Application No: AW/348/20/T  
Site Address: Malin House The Close Aldwick PO21 4EP  
Description of works: Fell 3 No. Holm Oak trees.

Thank you for your internet representation made on 22nd December 2020 which has been recorded as an objection with the comments as follows:

Tree Location Plan – Plan 1

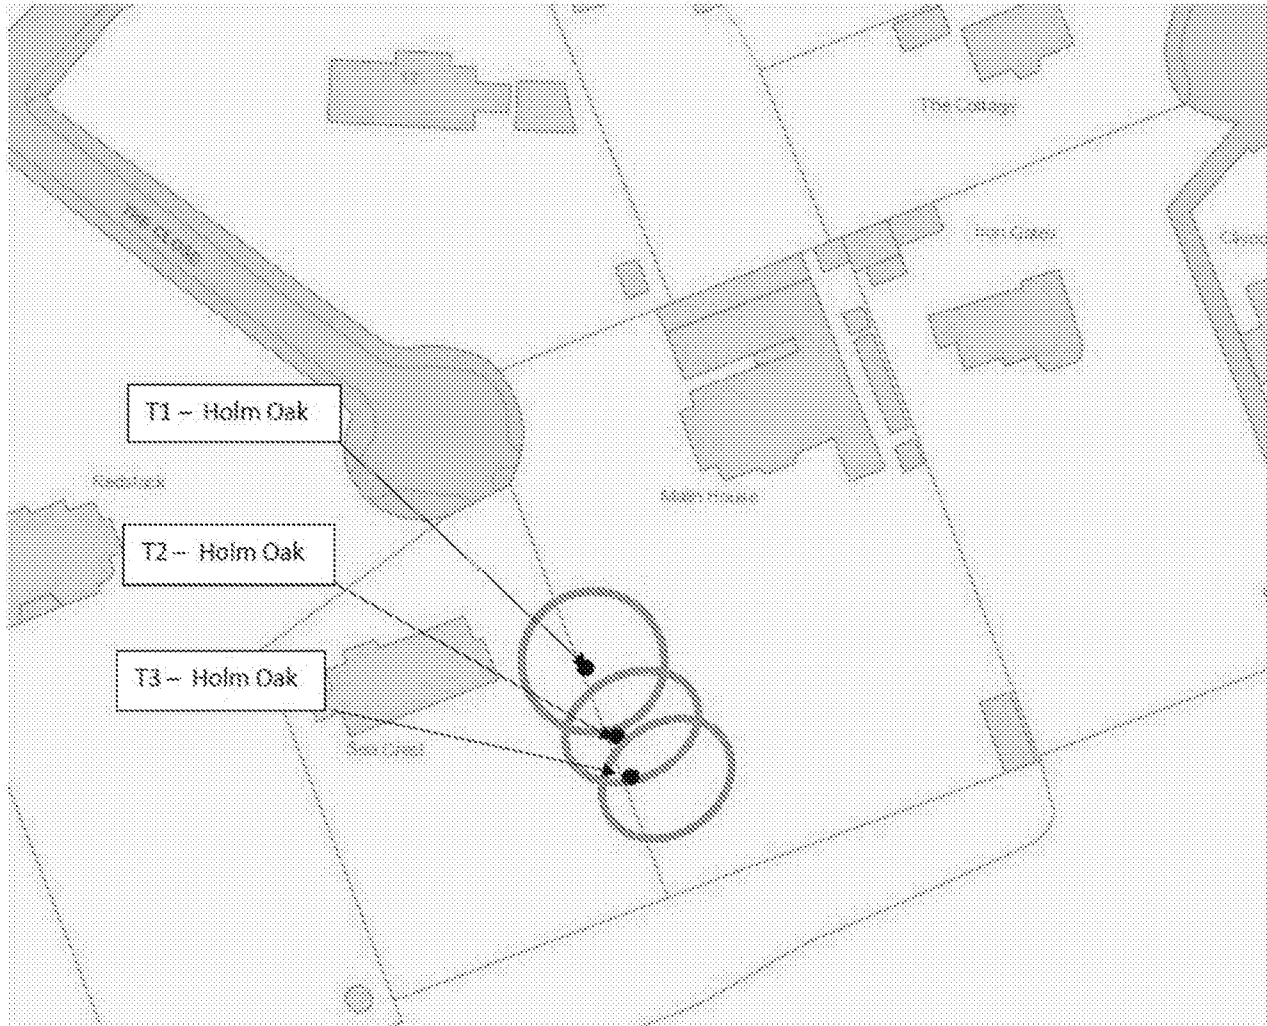
Members strongly objected to the application on the grounds that the trees are amenity trees and that it could be possible to move the wall closer to the house in order to accommodate the trees. Members expressed the hope that if the Arboriculturist recommends felling, that suitable replacement trees should be planted.
